CITY OF ALBUQUERQUE

December 22, 2015

**RE: Lot 13
Blue Sky Business Park
Grading and Drainage Plan (Stamp Date 11/3/2015)
Hydrology File: D16D002A5**

ZONE HAP NO. D-16 SHEET

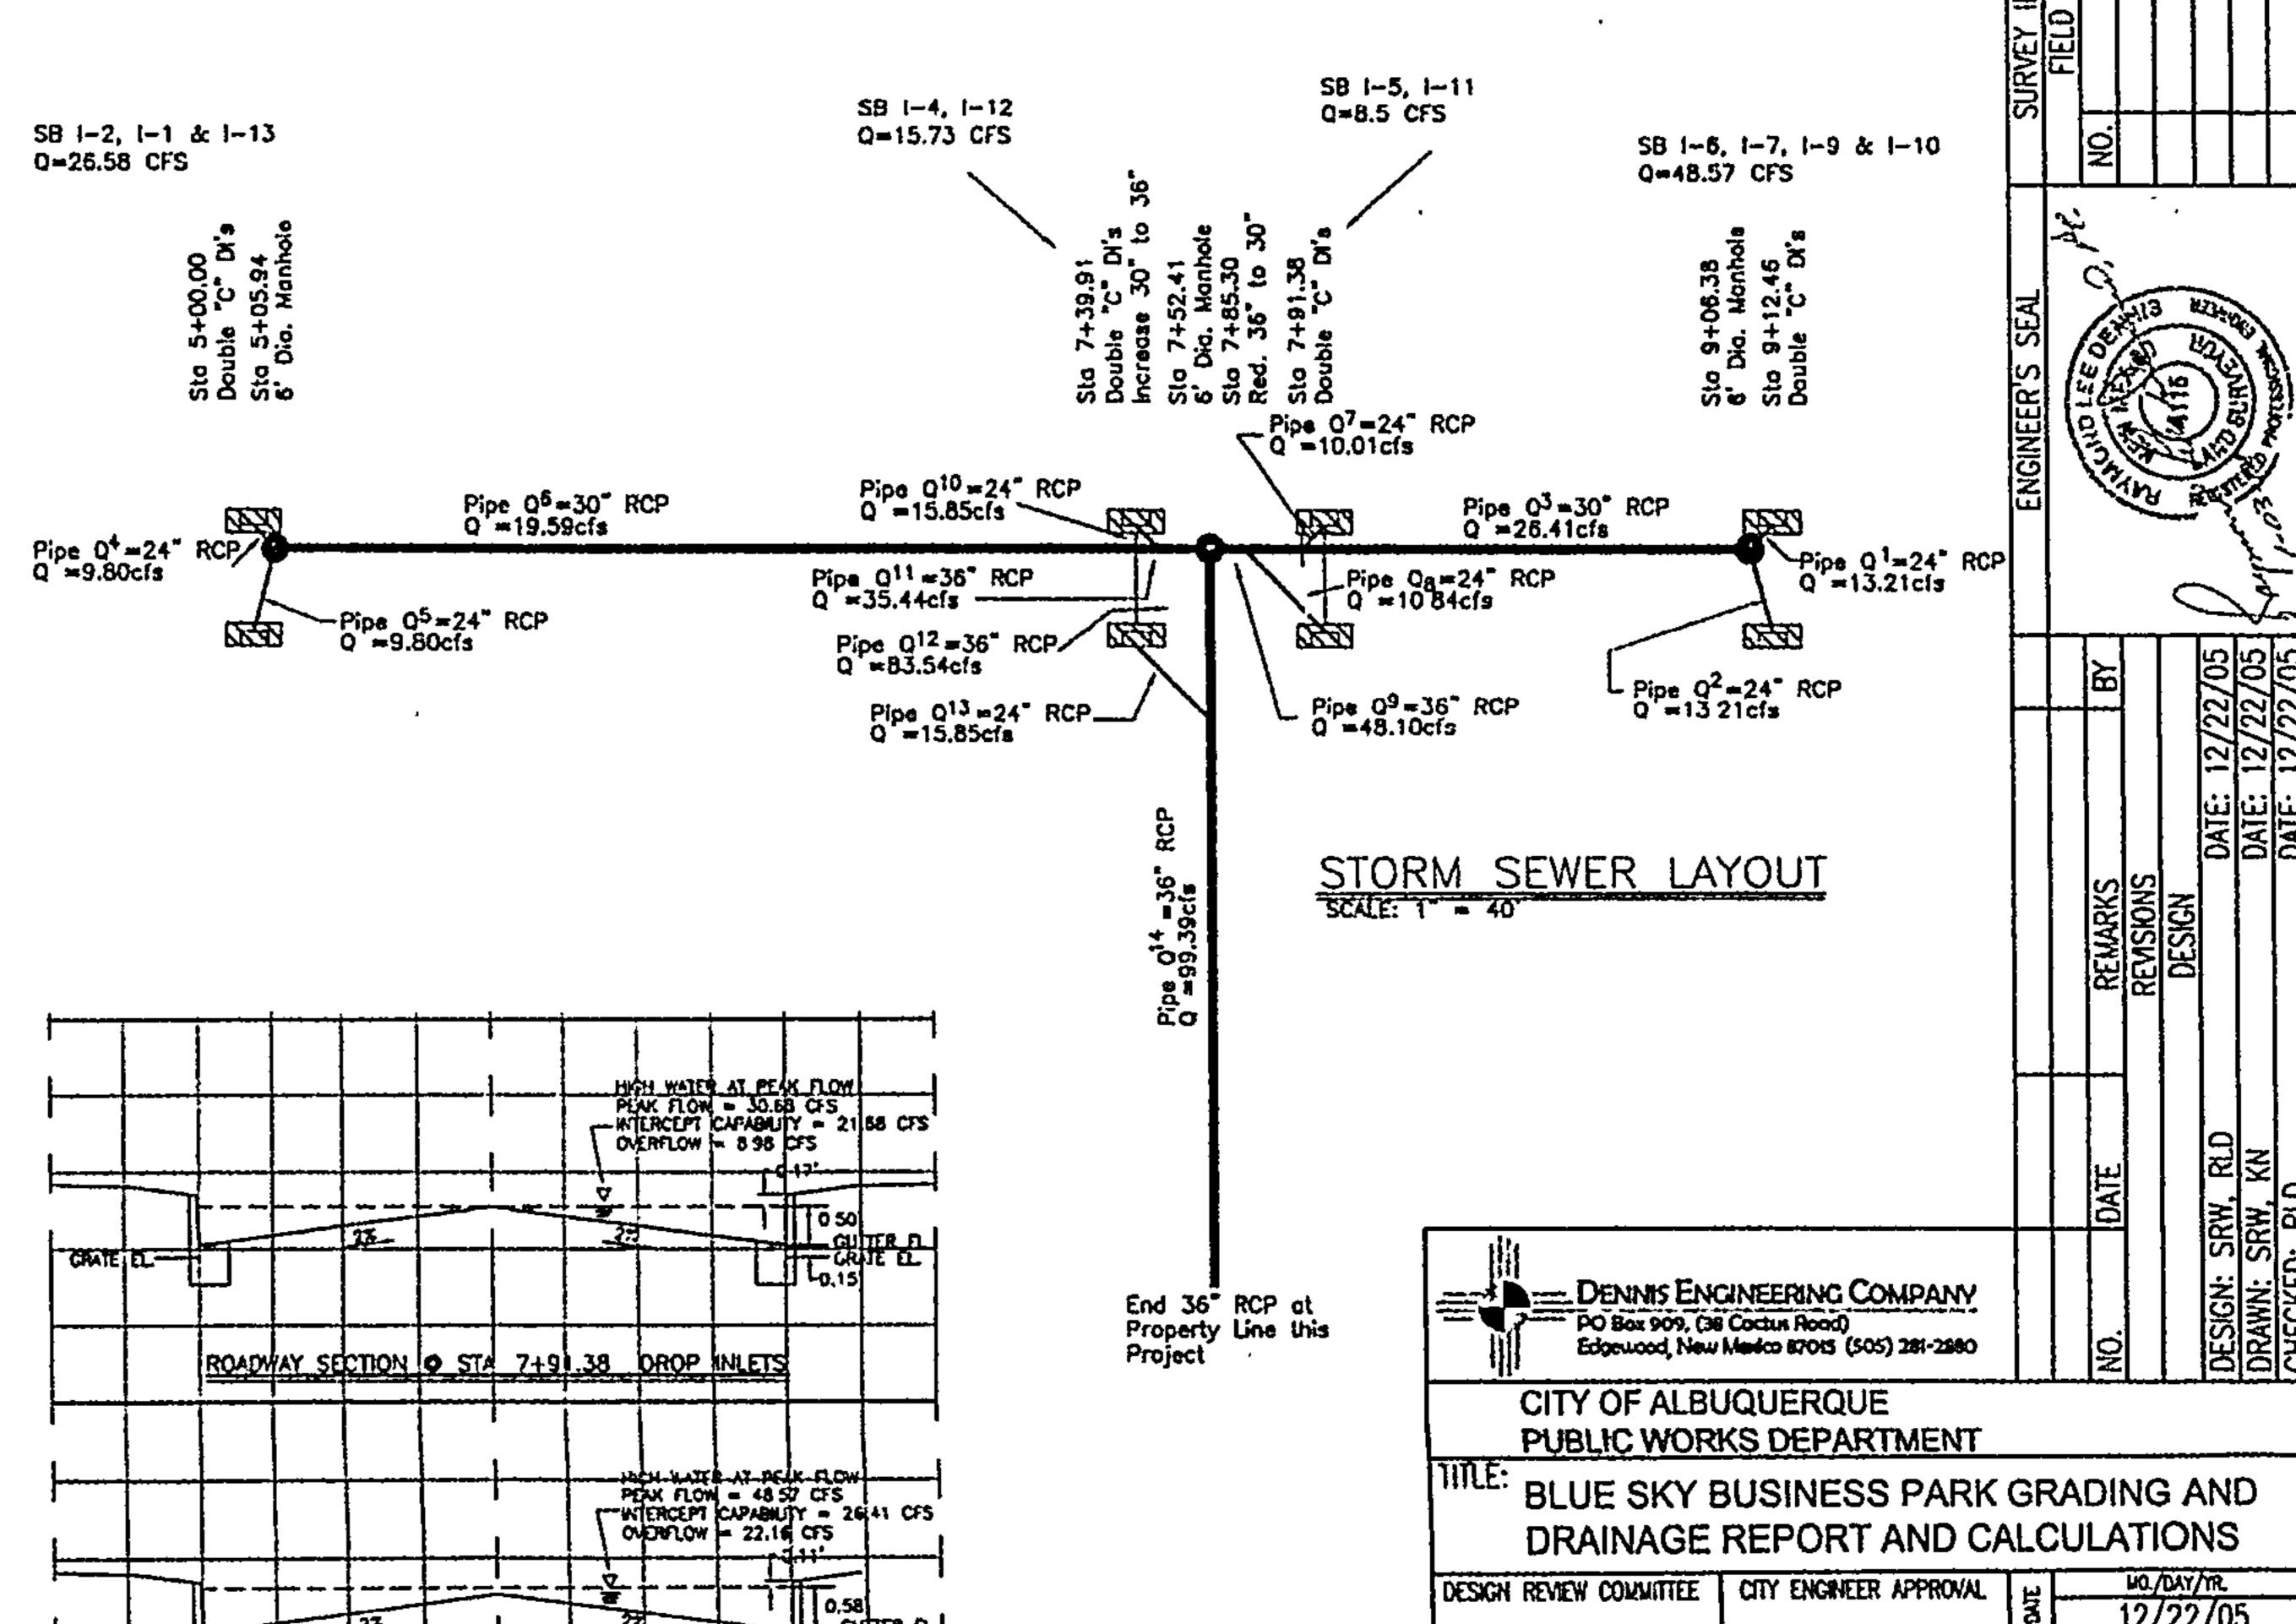
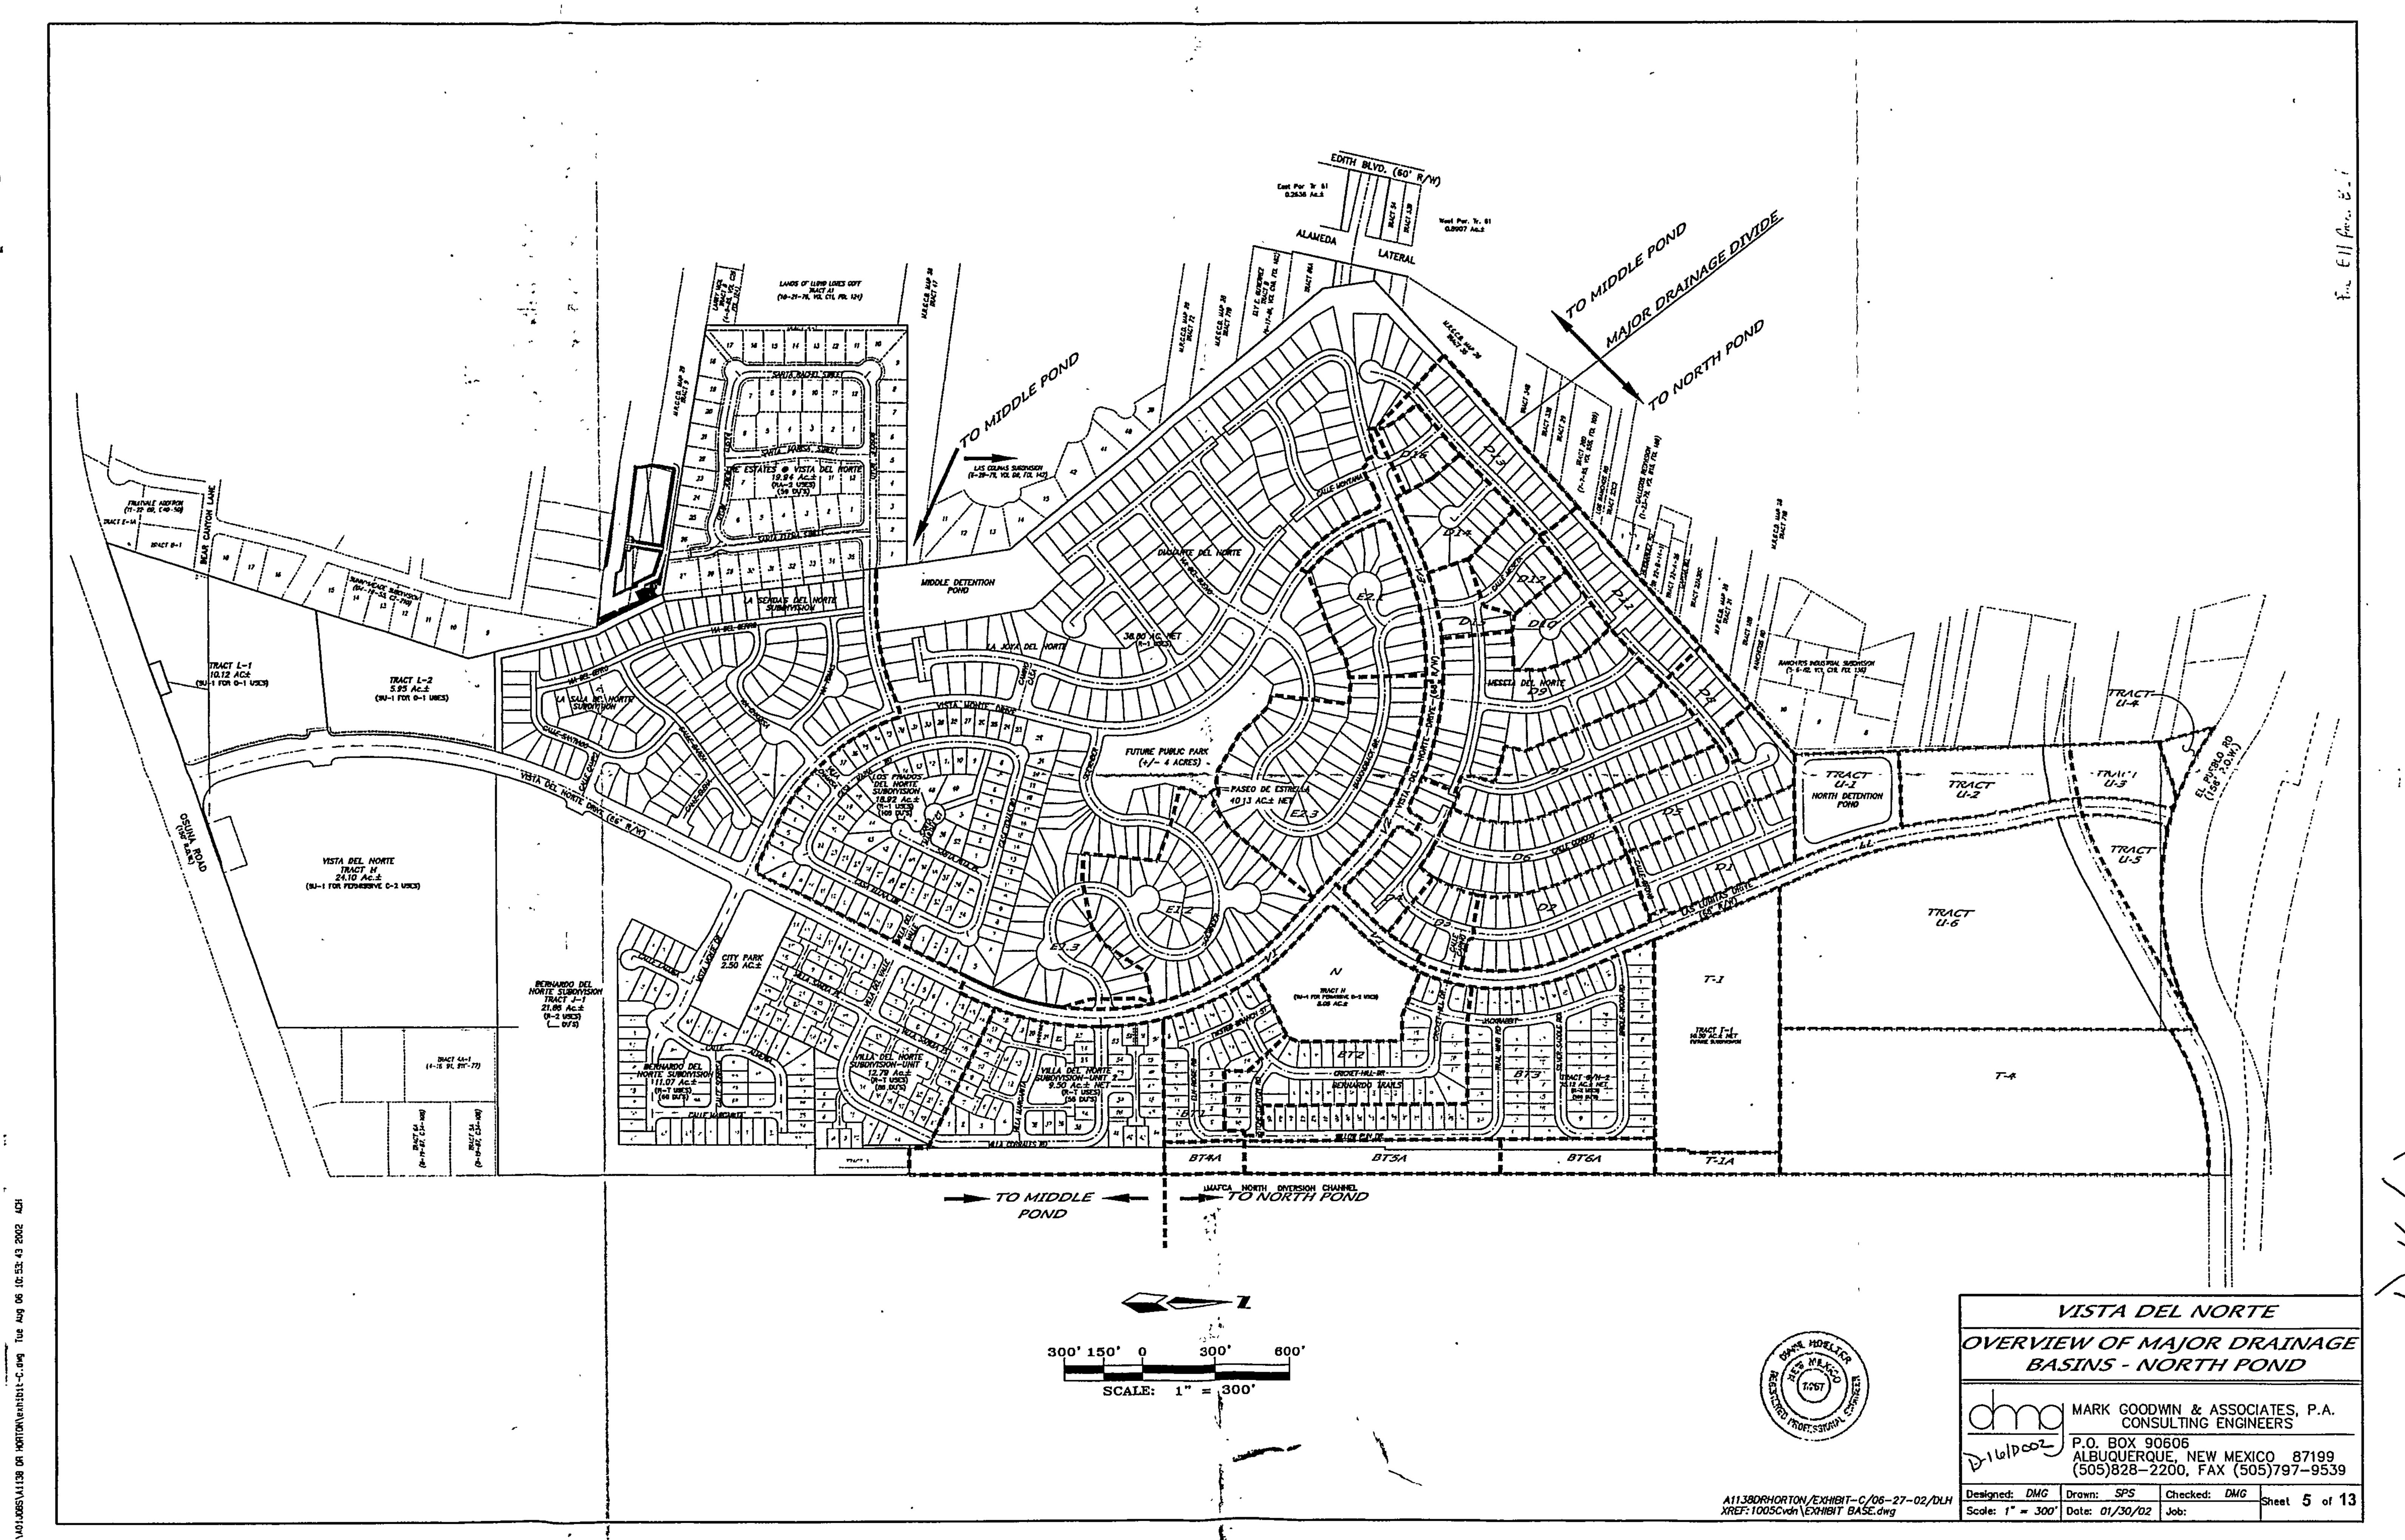
1. The Blue Sky Business Park Grading and Drainage Plan (2005), calculates the allowable discharge from this property (Sub-basin 1-13) including half of Jacs Lane. The drainage calculations for this project should match this format to confirm compliance with the overall plan. See attached Sheets 2 and 3 of the Grading Masterplan for the Development for reference.
